RE: Winrock Village Four, Drainage Analysis

February 17, 1977

SUBJECT: WINROCK VILLAGE FOUR, DRAINAGE ANALYSIS

site plan
1"= 50'-0"
76-097

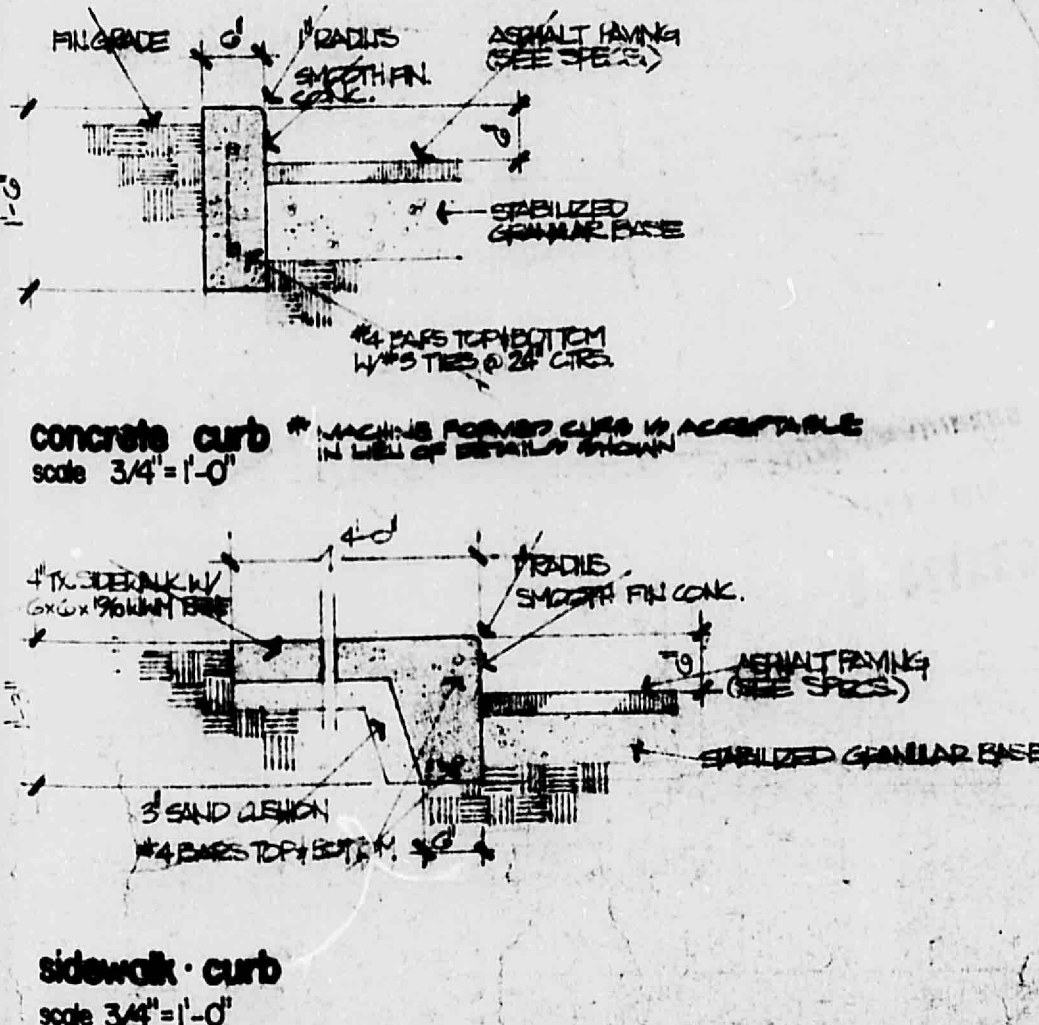
1. The I-40 drainage easement is on New Mexico Highway Department property, and use of the easement requires permission from that department.
2. There is a manhole located east of the last water line valve. It appears this line may fall within the proposed earth channel, unless it is the storm sewer which is to be removed.
3. The connection of the new earth channel on the southeast corner must have bank protection at the turn.
4. The elevation of the 42" water transmission line at the proposed earth channel should be determined to see if the channel is feasible.

Consideration should be given to relocating the earth bank to the west side of the channel to avoid the water line.

retaining wall. (An extension of the one shown in Section B-B.)

2. The manhole located east of the proposed earth channel has been located and it will not be disturbed. The City Water Department informed me that this is a terminal manhole for the 42" waterline tunnel under Pennsylvania Street, N.E. This manhole is now shown on Plate 2, which is attached as part of Addendum No. 1, dated February 22, 1977.

4. The elevation of the 42" transmission waterline south of this parcel of land has been determined. This waterline will not require lowering, but a concrete collar must be placed around it under the proposed channel. This concrete collar is now shown on Plate 2, which is attached as part of Addendum No. 1, dated February 22, 1977.

6. An alternate channel section has been added which uses riprap protection and a shallow footing retaining wall. This alternate section is shown on Plate 2 and noted as added by Addendum No. 1.
